K21/D09H2

To: Fred Arfman
Cc: Cloud, Jack W.
Subject: RE: Presidio Lot 155

Re: The Presidio Units Conversion Grading and Drainage Plan Certification
Engineer's Stamp date 10-18-11 (K21/D009H2)

### GRADING AND DRAINAGE 1 OF 5

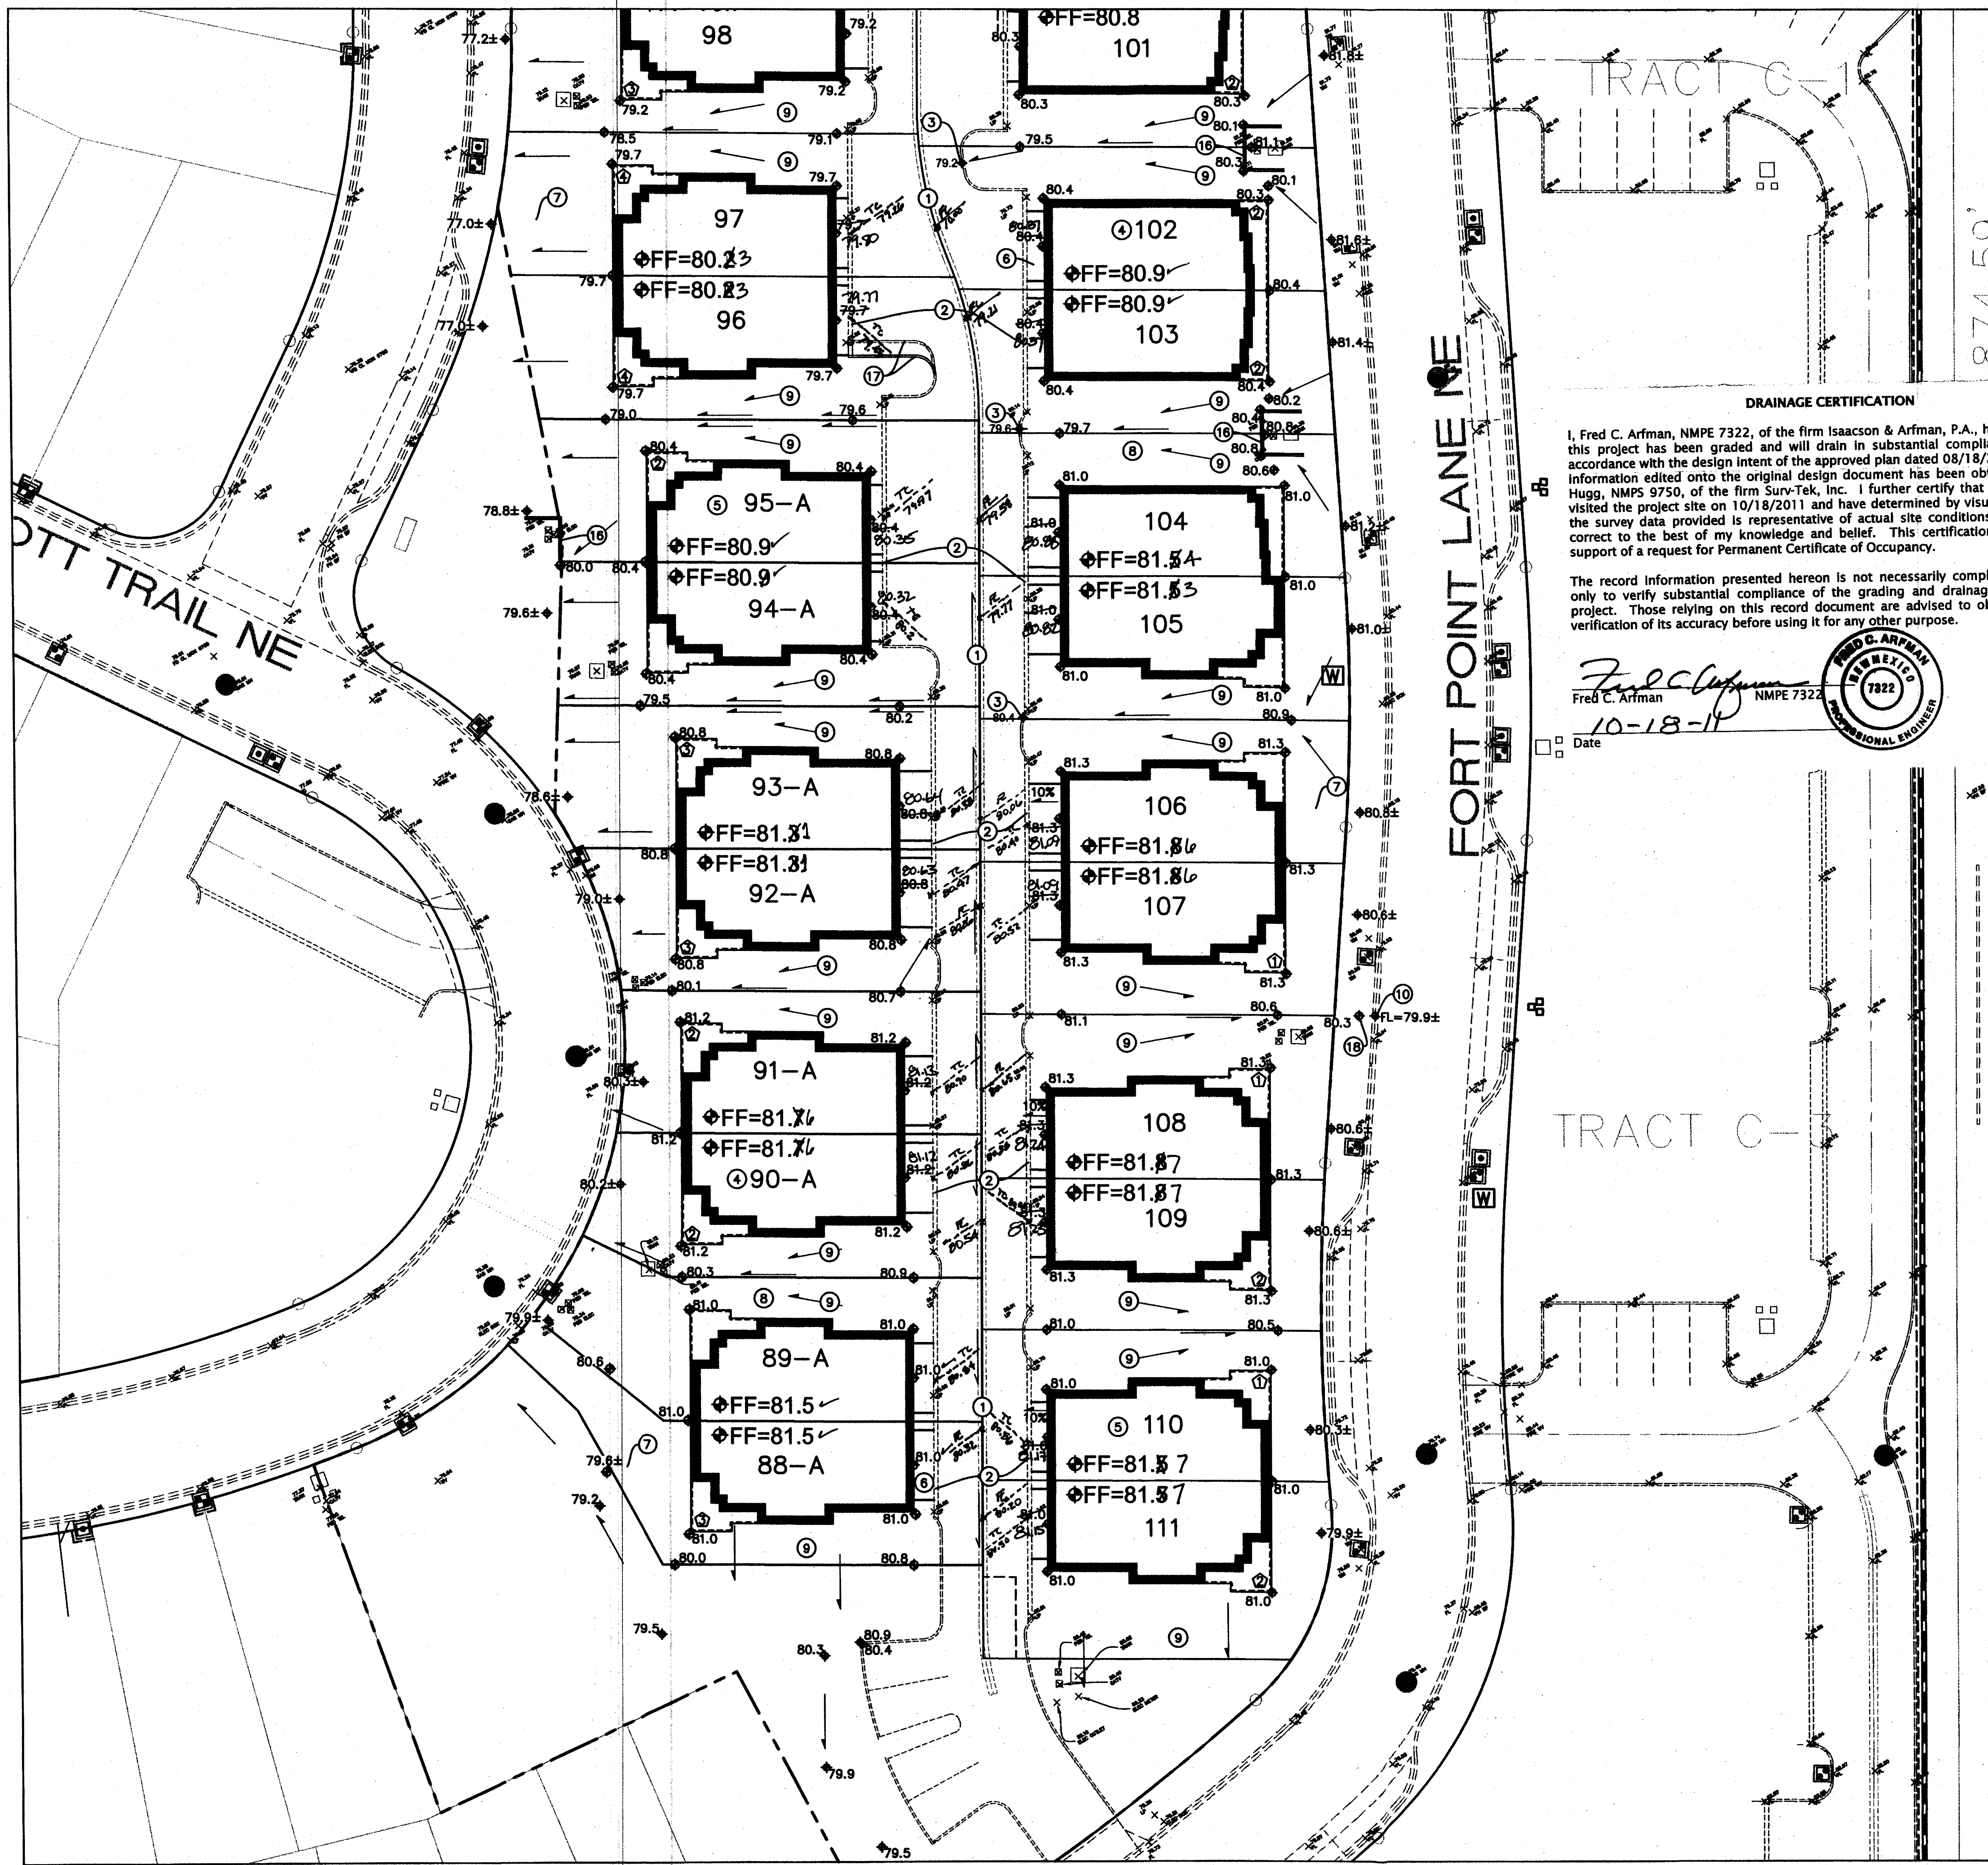
- Storm drain inlets were blocked in the subdivision. How is this area to drain as intended with the inlets mostly covered? The preferred BMP is to control erosion at the property line.
